**MODIFICATION REQUEST:
Residential Subdivision
Highview Drive, Dolphin Point
05_0024 MOD 1**

Director-General's
Environmental Assessment Report
Section 75W of the
Environmental Planning and Assessment Act 1979

July 2013

LEFT HAND TURNS

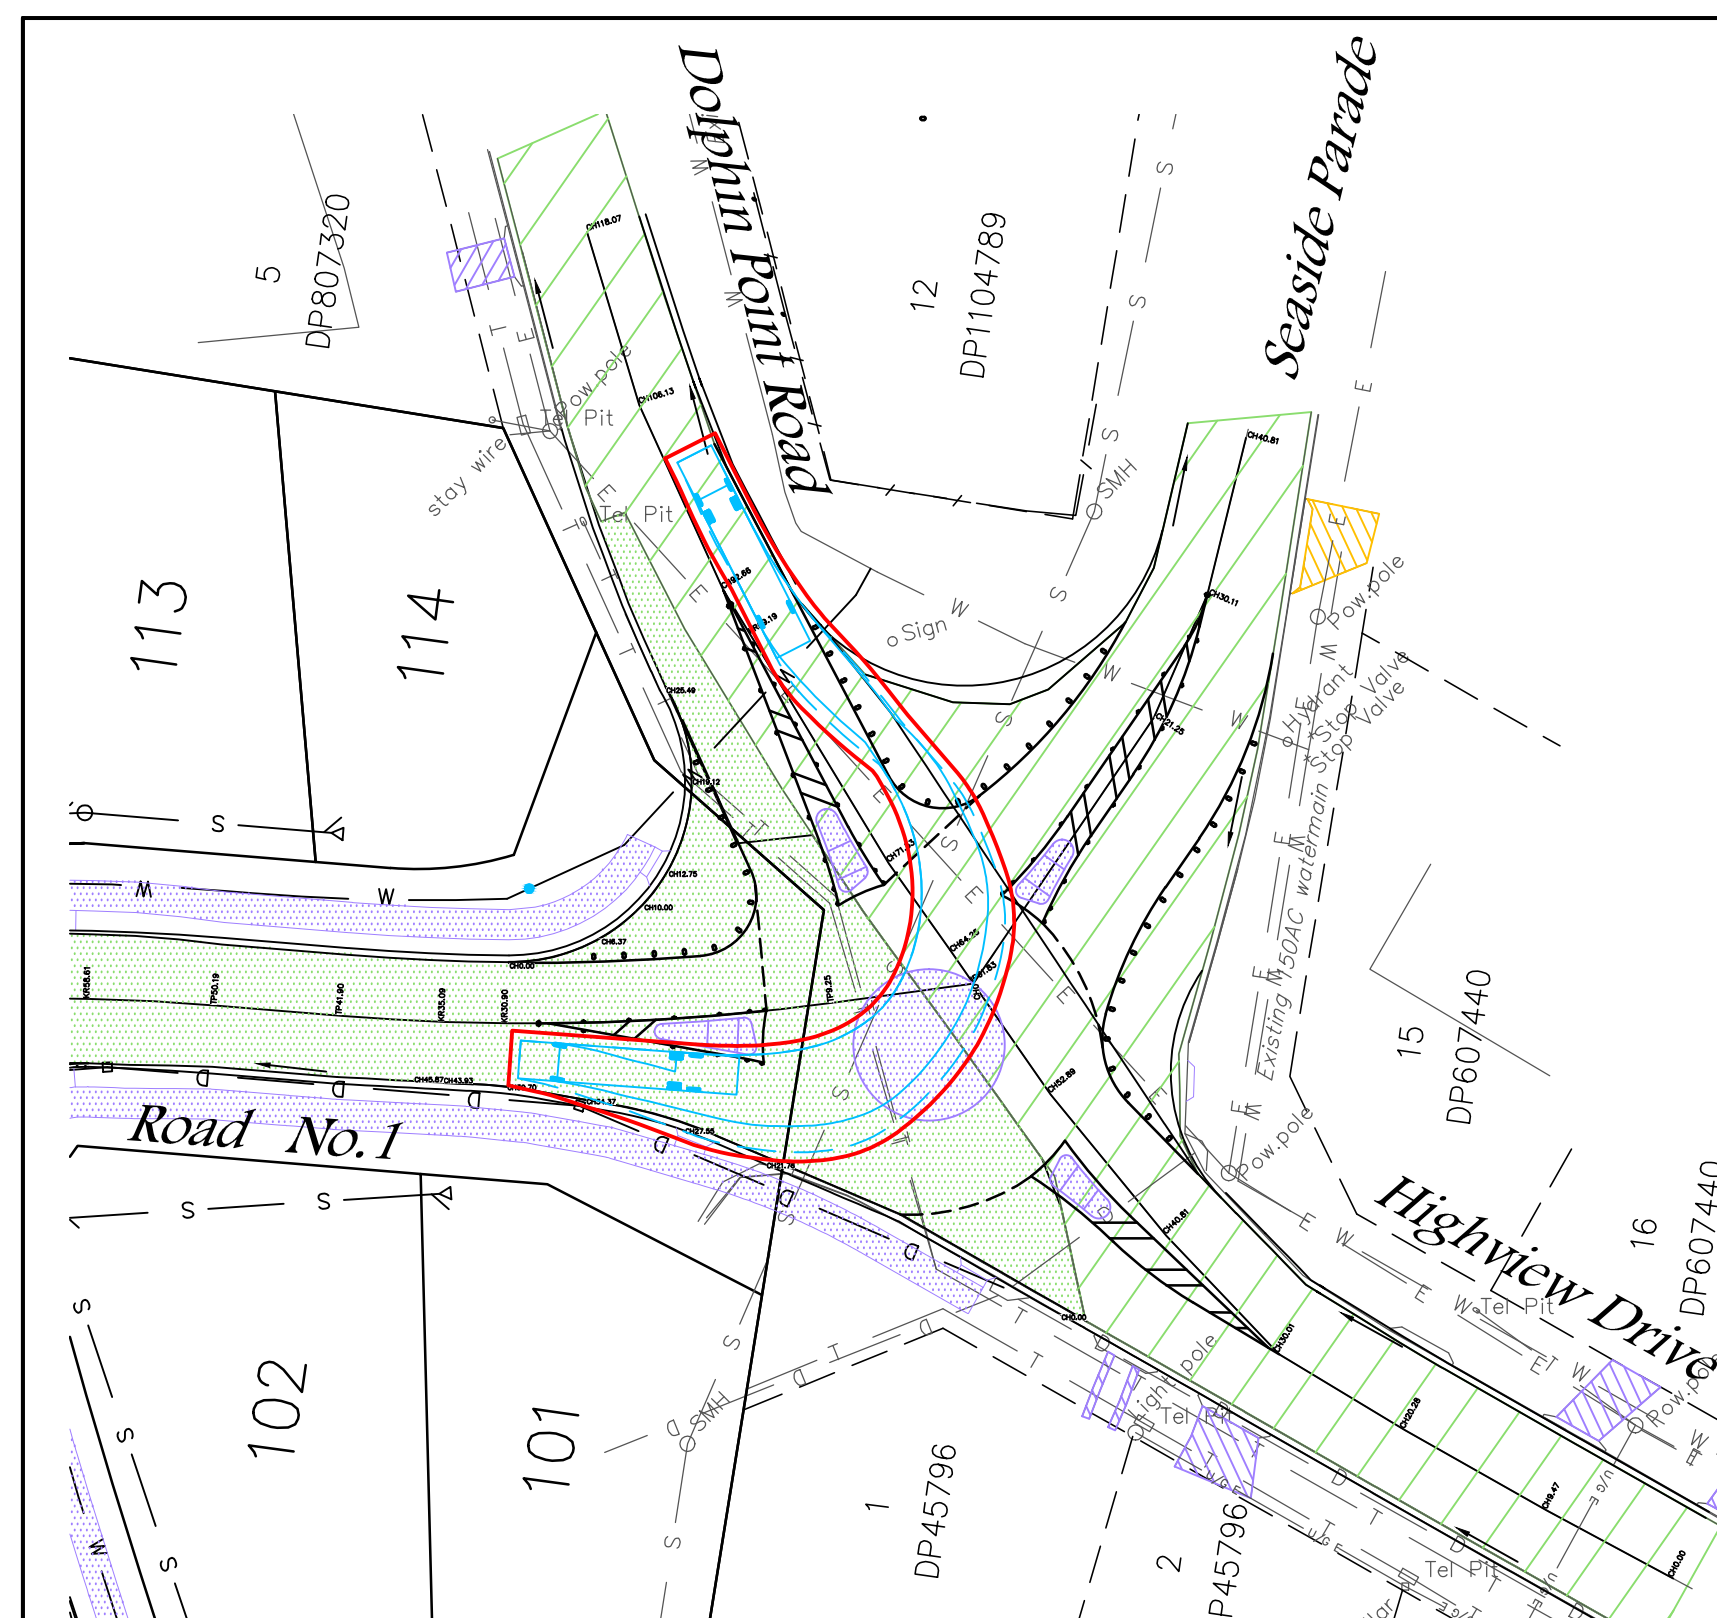
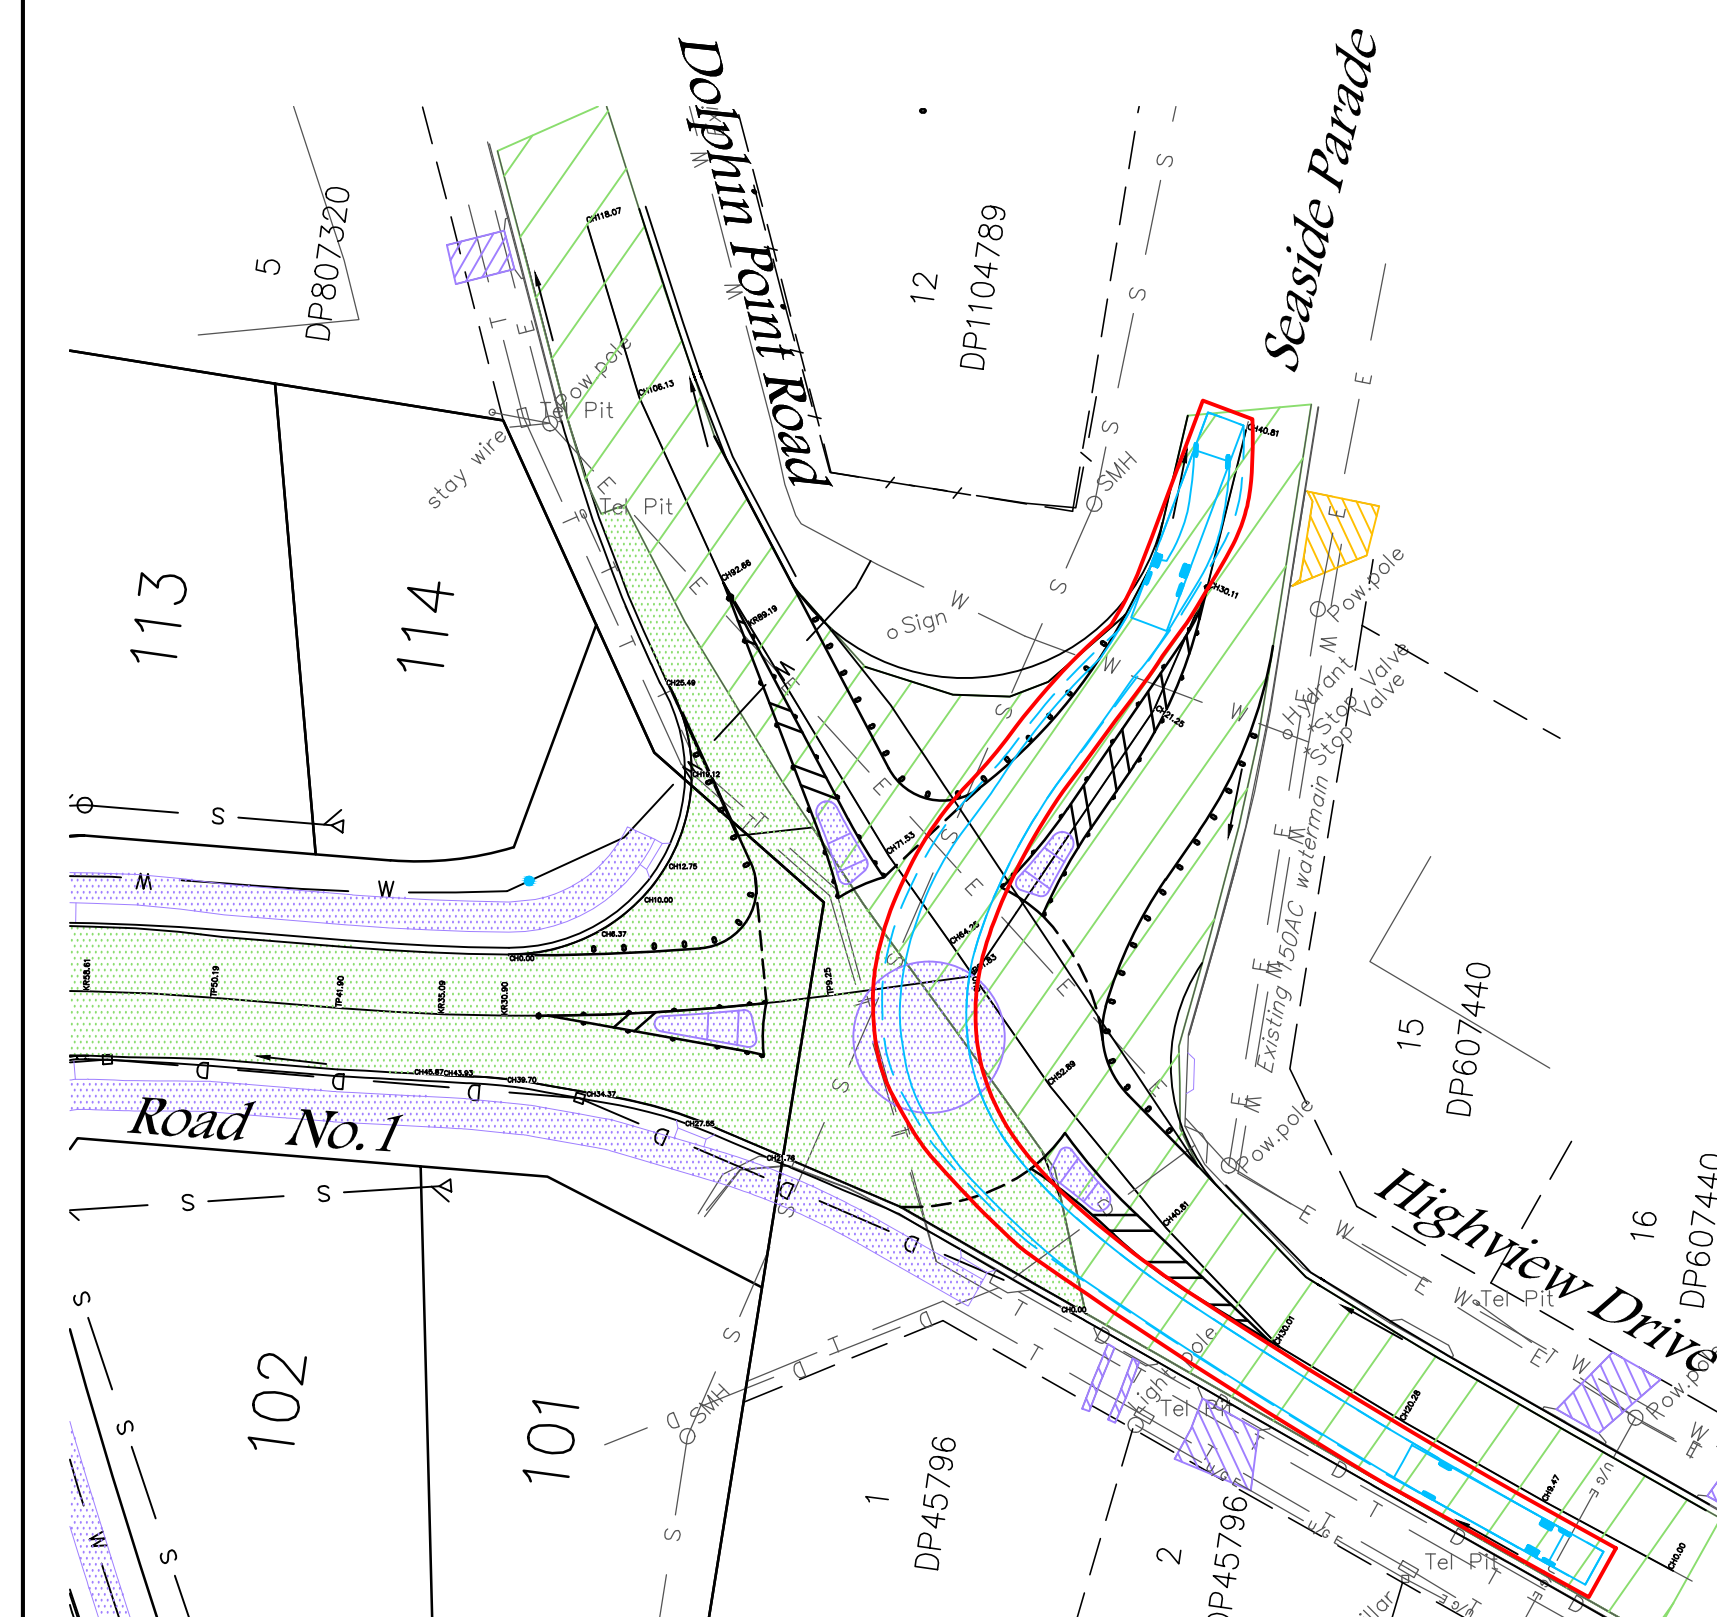
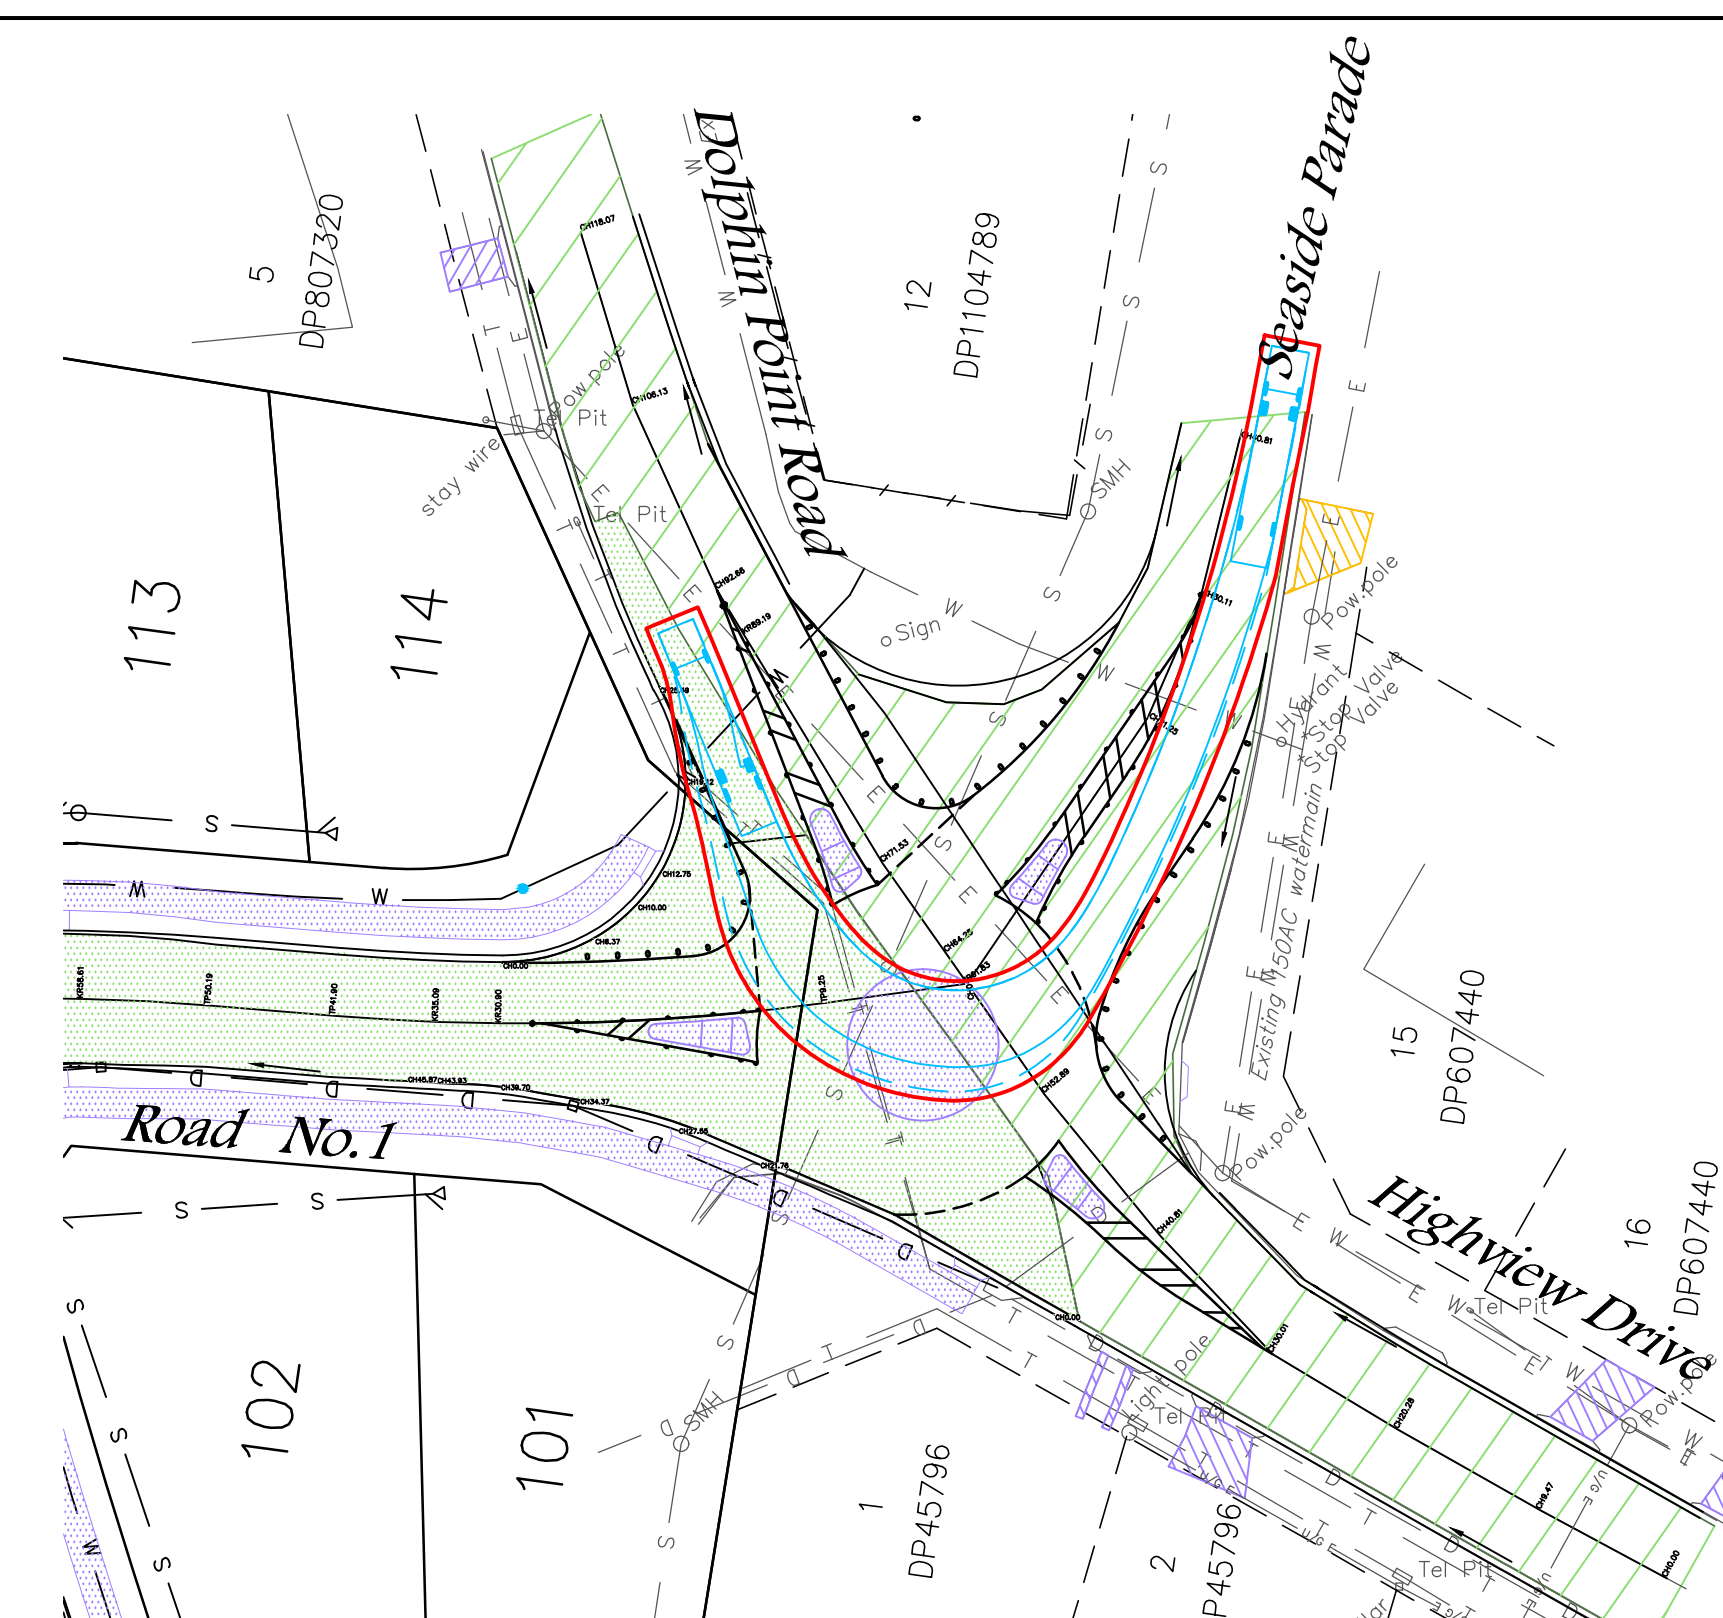
The proponent seeks to modify the design of the roundabout to provide a treatment which fits within the land available. A modified design incorporating a smaller inscribed circle of 22m in diameter with a mountable central island of 10m in diameter is proposed. In support of the modified design, the proponent provided advice from traffic consultants Colston Budd Hunt & Kafes Pty Ltd (CBH&K). CBH&K considered the revised roundabout dimensions were appropriate to cater for the types of vehicles which will use it, and that a larger roundabout at the location was not necessary. CBH&K provided swept path drawings for a 14.5m bus showing that a vehicle of this size will be able to use a roundabout of the size proposed (refer **Appendix C**).

Council objected to the proposed modification of Condition B19(4). Council suggested as an alternative that the final sentence of clause (4) which specifies the dimensions required of the roundabout be deleted. Council considered that the design criteria of the future roundabout will ultimately need to conform to the relevant Austroads standards, and that it is unnecessary to define the detailed roundabout dimensions as part of the condition.

The department concurs with council's advice and considers the future roundabout design and specific dimensions can be agreed upon between the proponent and council at such time the roundabout is to be constructed. This provides the proponent with a degree of flexibility as to the future design of the roundabout. Condition B19(4) is therefore amended to remove reference to the specific dimensions of the roundabout, with the future design of the roundabout to be prepared in consultation with council and in accordance with the relevant Austroads standards prior to the issue of a construction certificate.
